December 7, 2010

Re: 7 Luther Street, Peaks Island – 087 E025 – I-R2 Island Residential Zone –
unpermitted deck – Permit #10-1005

Proposed Plan
1/4" = 1'-0"

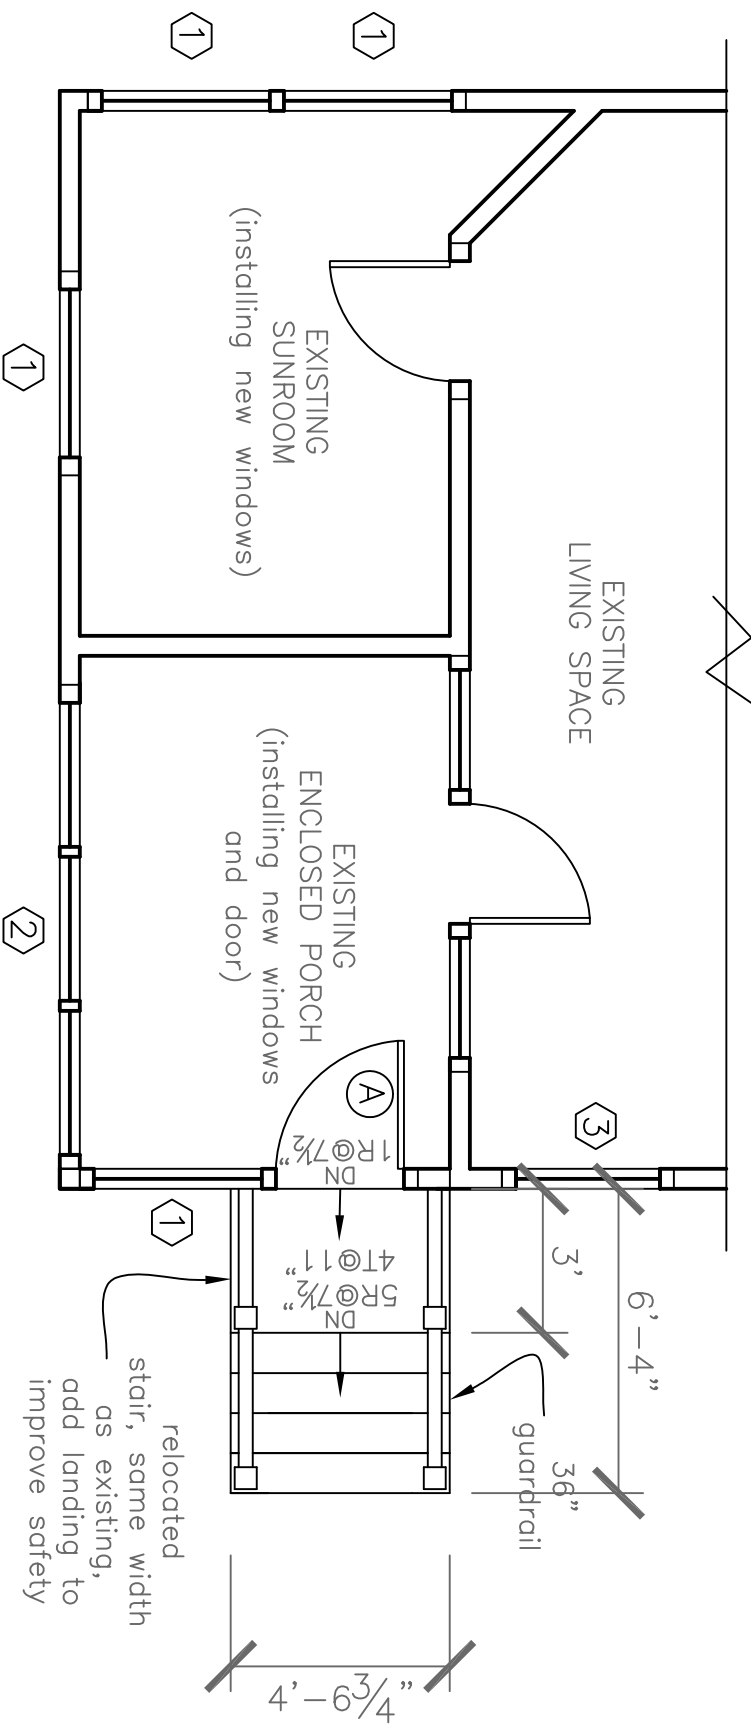
The proposed 12' x 8' deck does not meet all the zoning requirements. 7 Luther Street, Peaks Island is located in the I-R2 Island Residential Zone. The required rear setback is twenty-five (25) feet [section 14-145.11(c)(2)], but the setback for the proposed deck is twenty-four (24) feet. The maximum amount of land that the footprint of your structure can cover is twenty (20) percent [section 14-145.11(d)]. Twenty (20) percent of your lot is 880 square feet. The footprint of the existing structure is 943 square feet. The proposed deck and stairs would add 128 square feet for a total of 1071 square feet which covers 24.34 percent of the lot.

You need to bring your property into compliance. Since you cannot permit the deck under the zoning requirements, you must remove the deck. You have thirty days from the date of this letter to bring the property into compliance. If there is an existing door, you might be able to build steps that meet the minimum building code requirements to get from the door to grade. You would have to submit a revised plan showing this.
